CITY OF ALBUQUERQUE

April 3, 2020

**Re: Cornell 12-plex
200 & 202 Cornell SE
Traffic Circulation Layout
Engineer's 04-02-2020 (K16-D072A)**

SITE PLAN

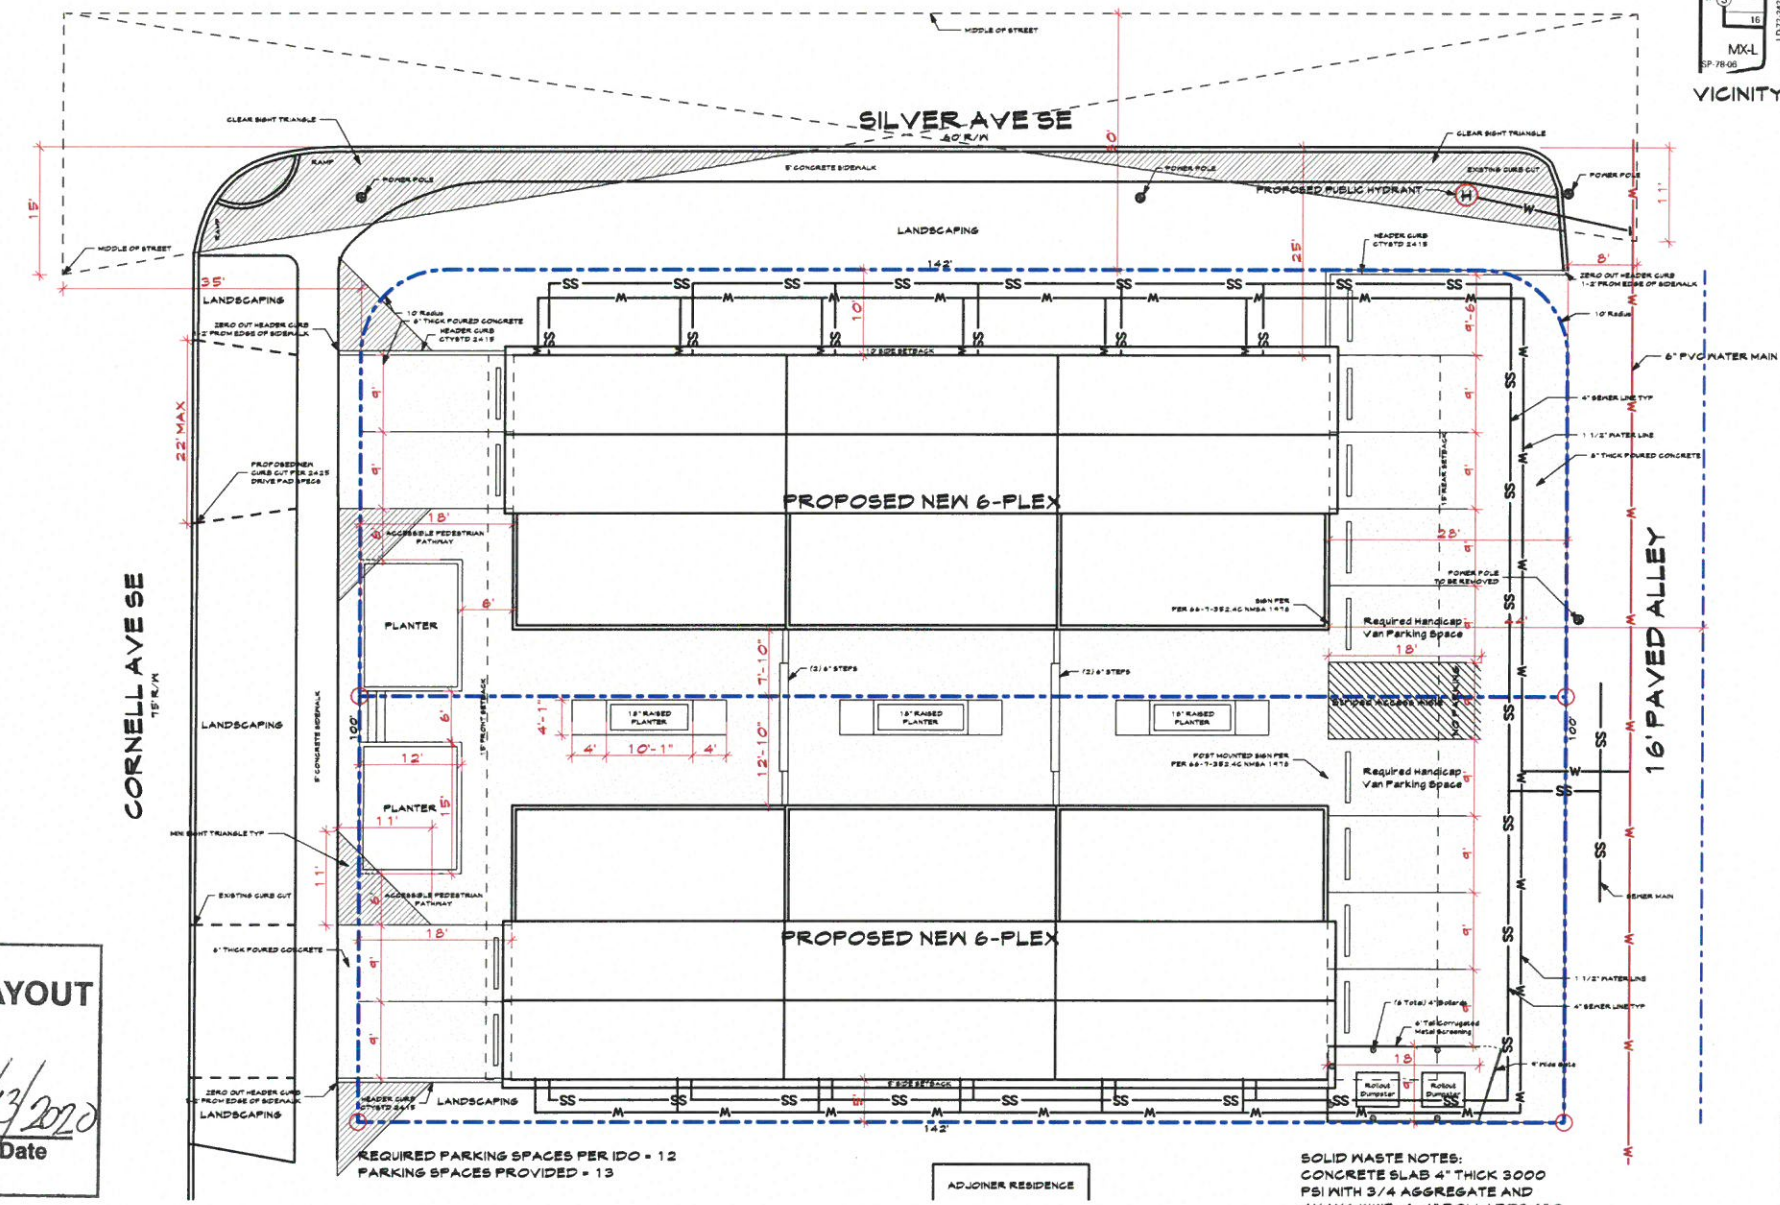
1. Please show a vicinity map showing the location of the development in relation to streets and well known landmarks.
2. List the number of parking spaces required by the zoning code as well as the proposed number of parking spaces including bicycle and motorcycle parking. Please coordinate all calculations for parking spaces, including bicycle, and motorcycle parking with Zoning.
3. Identify all existing access easements (Private land) and rights of way width dimensions (public street).
4. Clarify existing property lines and proposed property lines.
5. Please list the width and length for proposed parking spaces. Some dimensions are not shown.
6. The minimum parking stall dimensions are:

7. The ADA accessible spaces must include an access aisle. Van accessible aisles should be 8ft wide; all others should be 5ft wide.

8. The ADA accessible parking sign must have the required language per 66-7-352.4C NMSA 1978 **"Violators Are Subject to a Fine and/or Towing."** Please call out detail and location of signs.

9. The ADA access aisles shall have the words **"NO PARKING"** in capital letters, each of which shall be at least one foot high and at least two inches wide, placed at the rear of the parking space so as to be close to where an adjacent vehicle's rear tire would be placed. (66-1-4.1.B NMSA 1978)

10. Motorcycle parking spaces shall be designated by its own conspicuously posted upright sign, either free-standing or wall mounted per the zoning code. Label pavement(**if applicable**).

15. Per the IDO, a 6 ft. wide ADA accessible pedestrian pathway is required from the public sidewalk to the building entrances. **Please clearly show this pathway and provide details.**

16. Per DPM, a 6 ft. wide ADA accessible pedestrian pathway is required from the ADA parking stall access aisles to the building entrances. **Please clearly show this pathway and provide details.**

17. Curbing needs to be zero at connection of public sidewalk to avoid any safety issues.. Please call out detail barrier curb.
18. Refuse vehicle maneuvering shall be contained on-site. The refuse vehicle shall not back into the public right of way (alley way). Provide a copy of refuse approval.

19. It is not apparent what type of pavement surface is being proposed. A hard driving surface will be required as part of this proposed project for parking area and drive aisles.

20. Please provide a sight distance exhibit (see attachment for exhibit).
21. Show the clear sight triangle and add the following note to the plan:
"Landscaping and signage will not interfere with clear sight requirements. Therefore, signs, walls, trees, and shrubbery between 3 and 8 feet tall (as measured from the gutter pan) will not be acceptable in the clear sight triangle."

29. No vehicles will be allowed to park in existing 16 ft alley way. Please added to this reference.
